From: [REDACTED]
To: [M25 Junction 28](#)
Subject: Gardens of Peace - comments on responses to Written Representation
Date: 25 February 2021 19:40:22
Attachments: [20200225 - Comments on Responses to WR's - Final.pdf](#)

Savills, on behalf of Gardens of Peace Muslim Cemetery, submit the following comments in regards to Highways England's response to the Written Representation. We first outline our comments to each specific response (Part 1), before providing a key summary of comments on Highways England's Responses (Part 2). We reserve the right to discuss the below points, and the concerns highlighted within the Written Representation, in greater detail during the oral hearing.

**highways england**

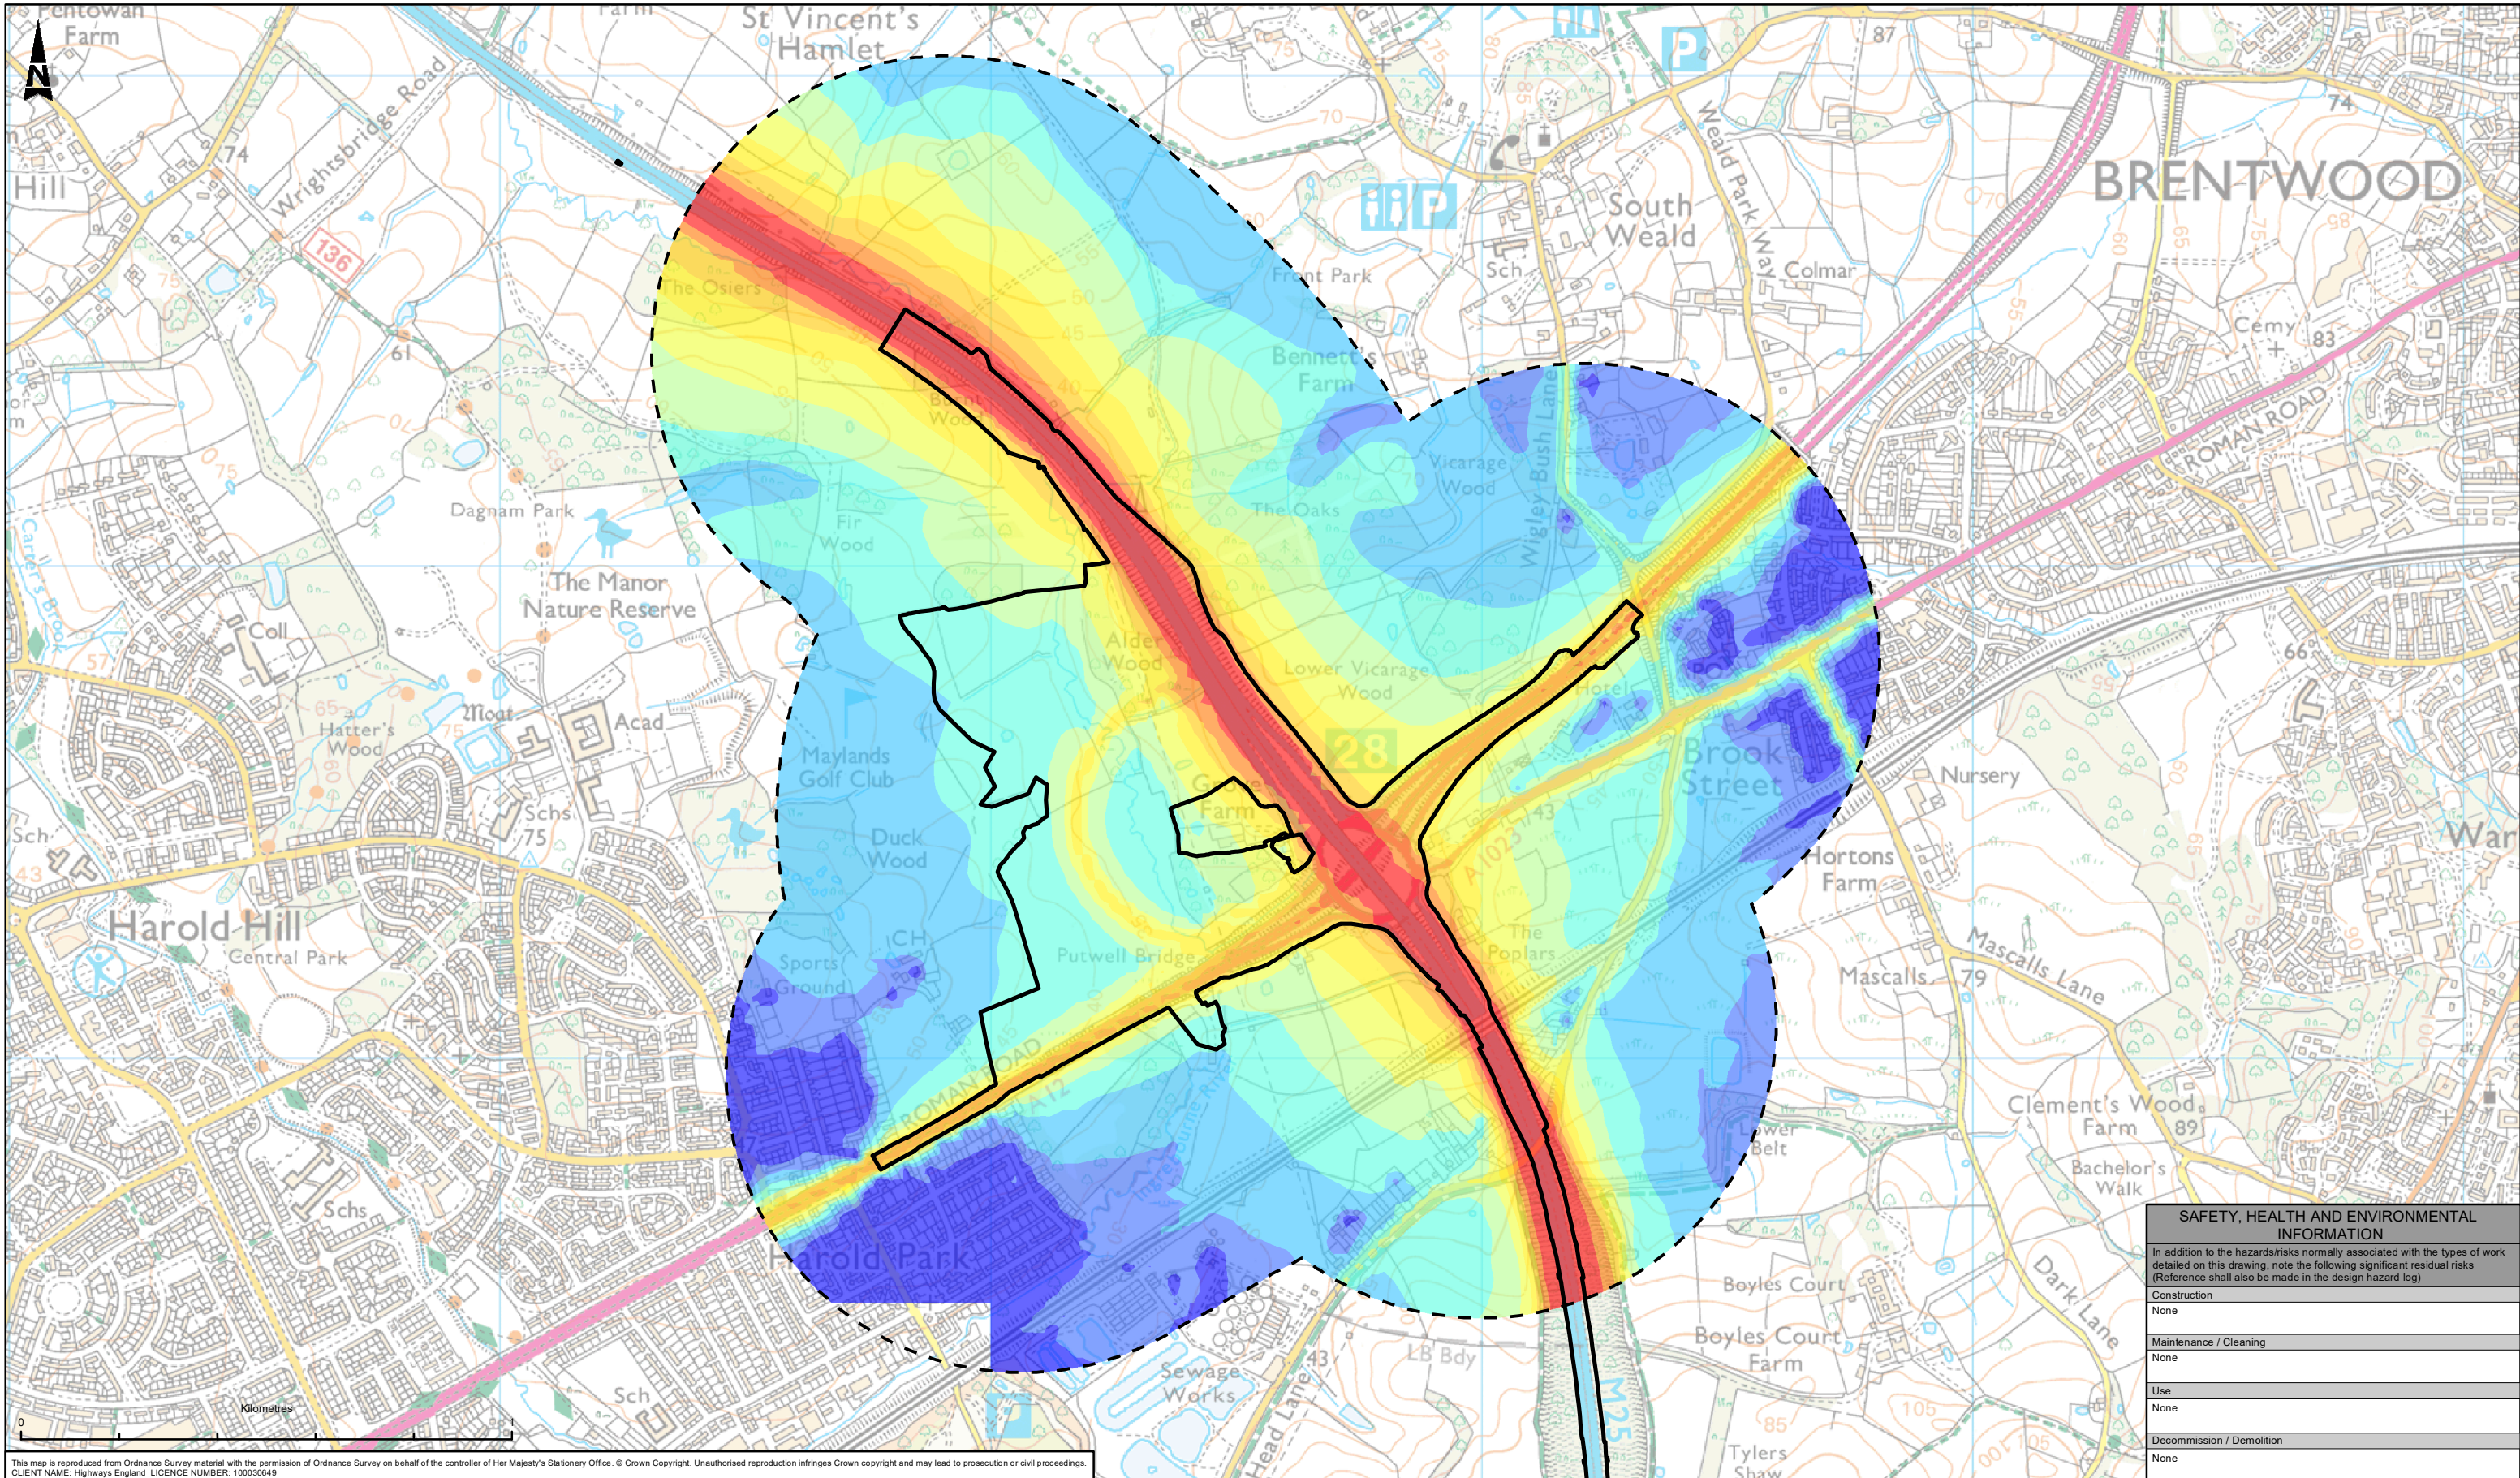
Gardens of Peace welcome the clarification on the expected reduction in noise level of 1dB.

The noise impacts at the Gardens of Peace can be seen on the noise contours in the ES (Figures 6.5 to 6.15, APP-041), and the impacts are summarised in point 12.1.1 of the Statement of Common Ground with London Borough of Havering (REP1-004). For further clarity a receptor position has been added for the Gardens of Peace and this is presented in the update of the Noise Chapter 6 of the ES (TR010029/APP/6.1(2)) submitted at this Deadline 3a. The Gardens of Peace receptor is included in the tables of receptors in the updated Appendix 6.3 (TR010029/APP/6.3(2)) submitted at Deadline 3a. The table below is extracting the noise results from Table 6.1 of the updated Appendix 6.3 (TR010029/APP/6.3(2)). The changes in noise expected at the Gardens of Peace are decreases in noise smaller than 1dB.

#### 9.59 Overlay plan of Plot 1/8 and the burial plots

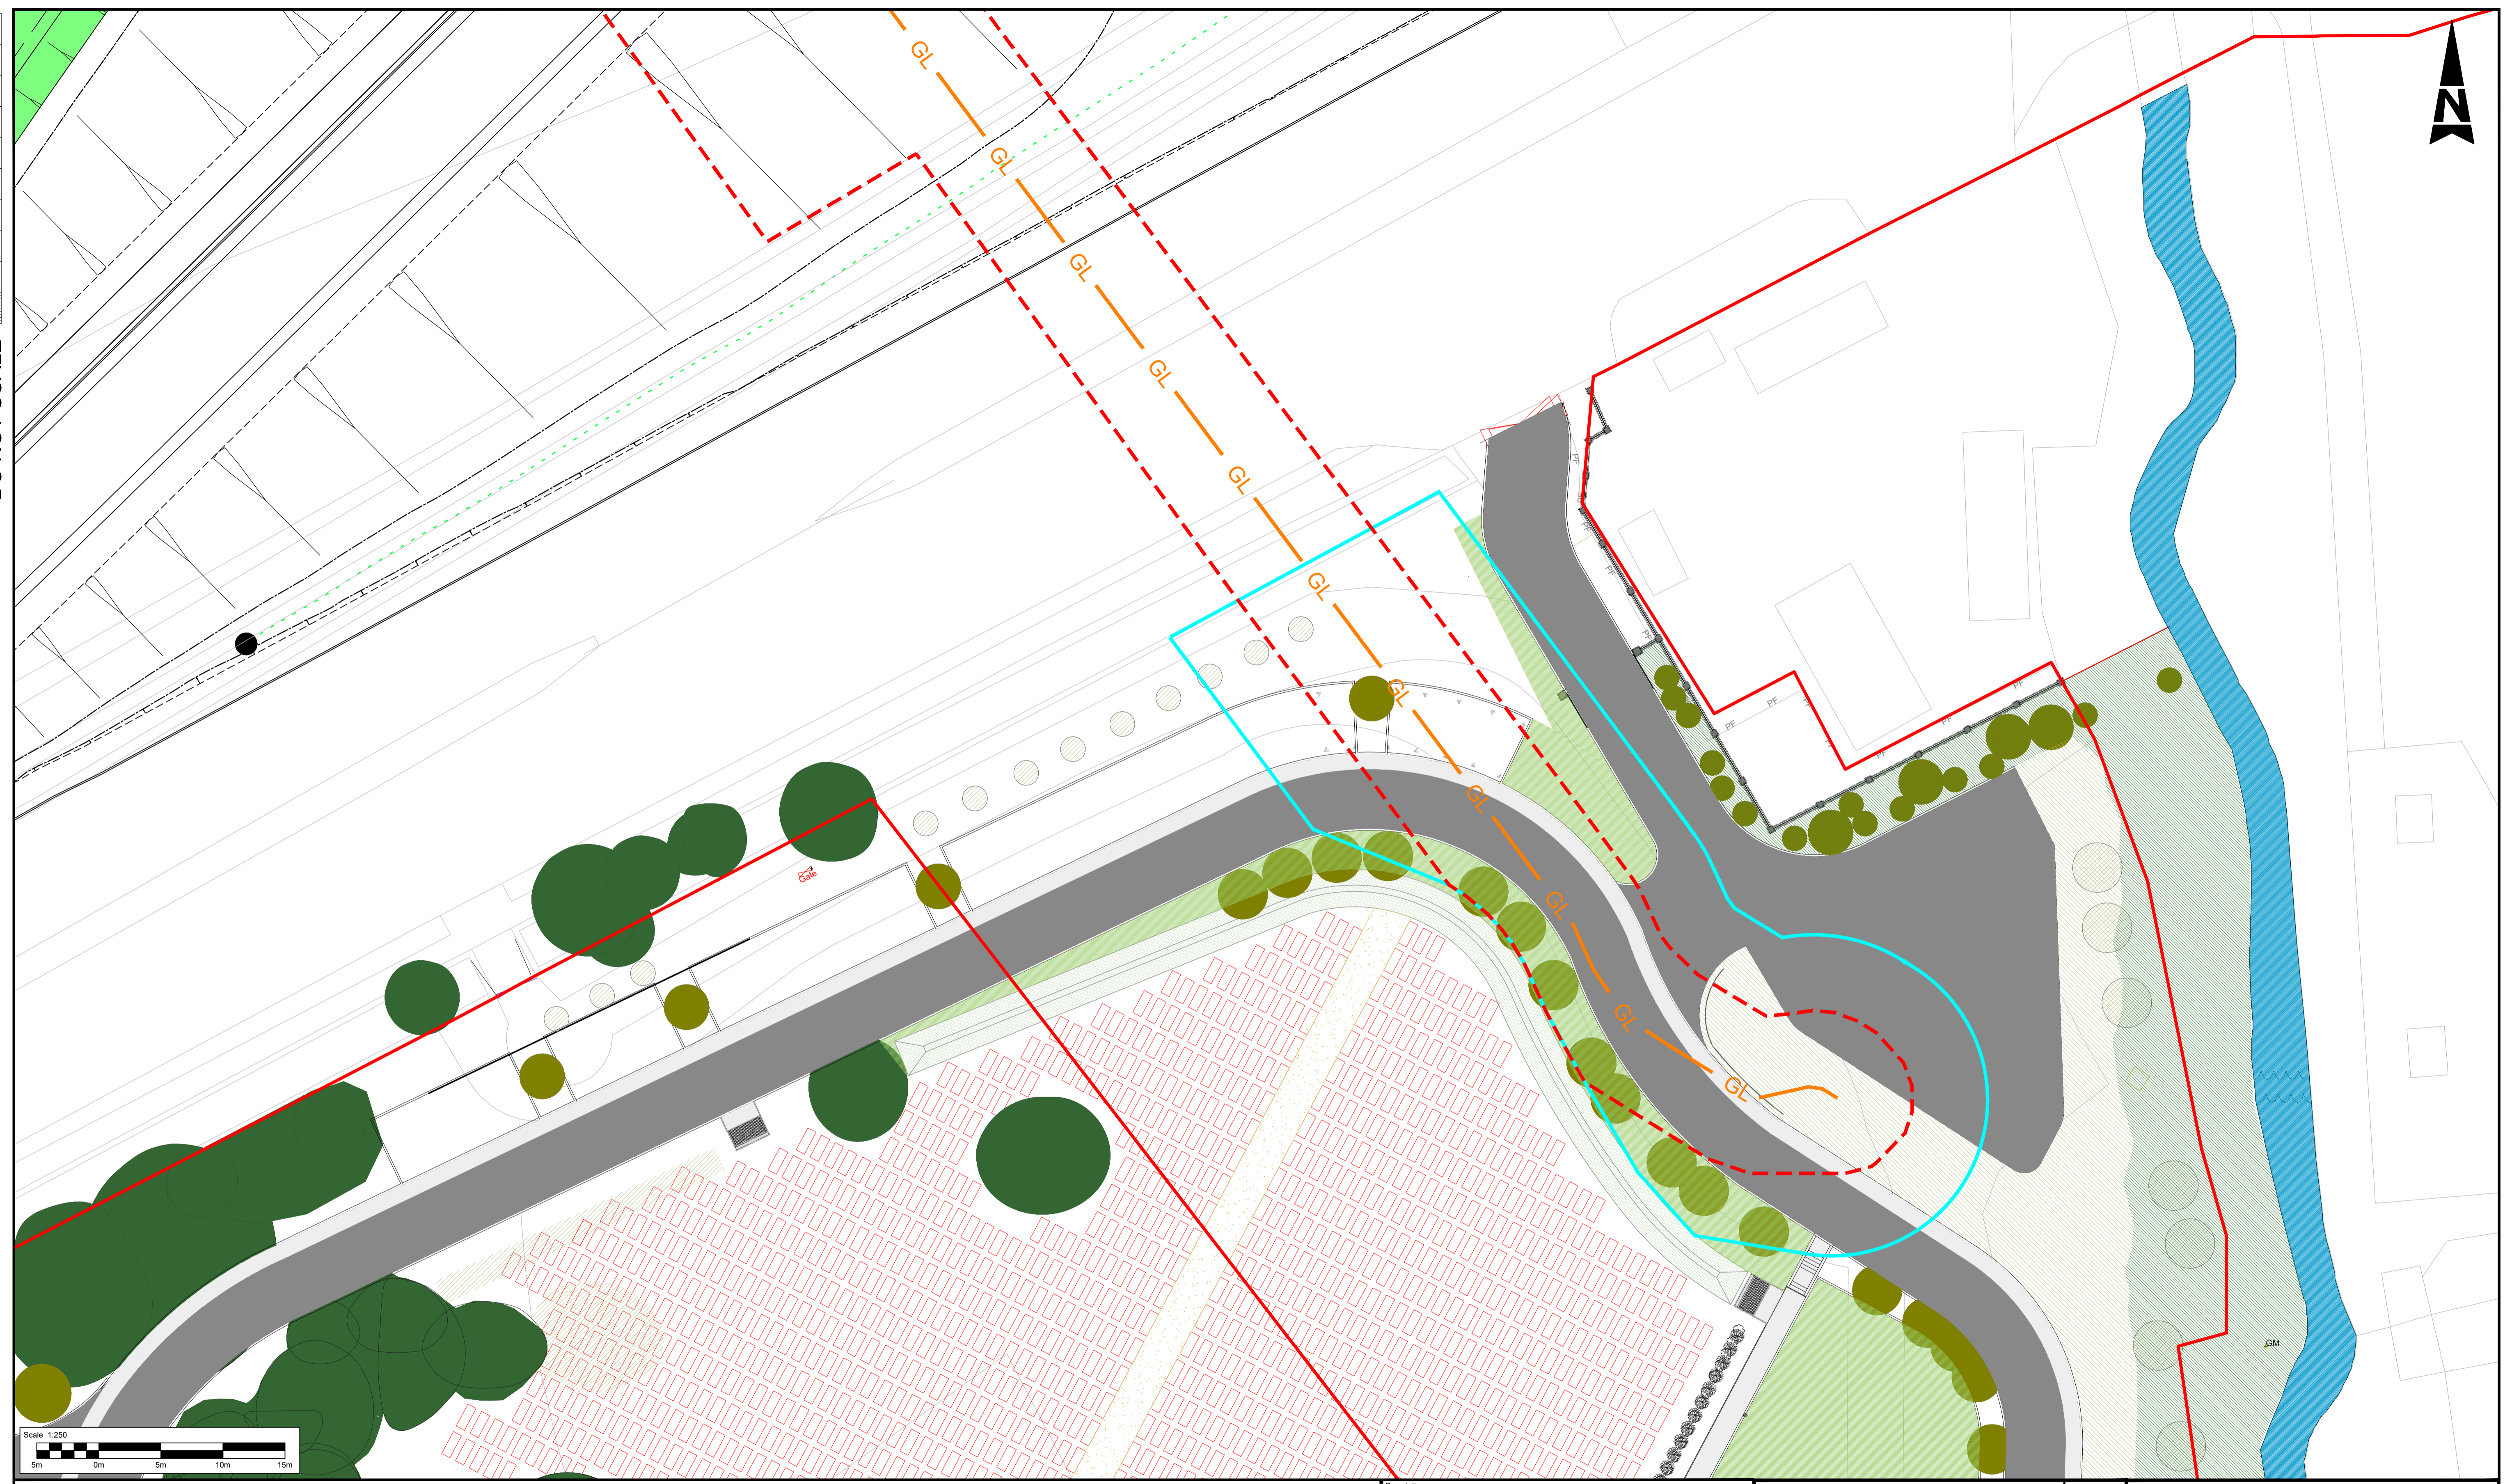
Highways England and Cadent has engaged with Gardens of Peace concerning the potential reduction in the area that will be subject to acquisition of permanent rights within Plot 1/8. As stated previously, this is

welcomed by Gardens of Peace. Notwithstanding this, and as highlighted within the Written Representation, despite the engagement between parties, there has been no formal confirmation on how the issues, that will still arise despite the potential amendments to Plot 1/8, will be mitigated.

Highways England refer to Gardens of Peace welcoming the proposed changes outlined with the recent non-statutory consultation. Whilst Gardens of Peace do support the proposed reduction in area of land to be subject to acquisition of permanent rights within Plot 1/8, there will still be significant temporary issues as a result of the Scheme (as previously stated within former submissions to the Examining Authority and Highways England). Whilst highways England and Cadent have discussed these issues with Gardens of Peace in meetings, there has been no formal confirmation on how Highways England intend to mitigate the impacts resulting from the issues highlighted within the meetings (and reiterated within the Written Representation).
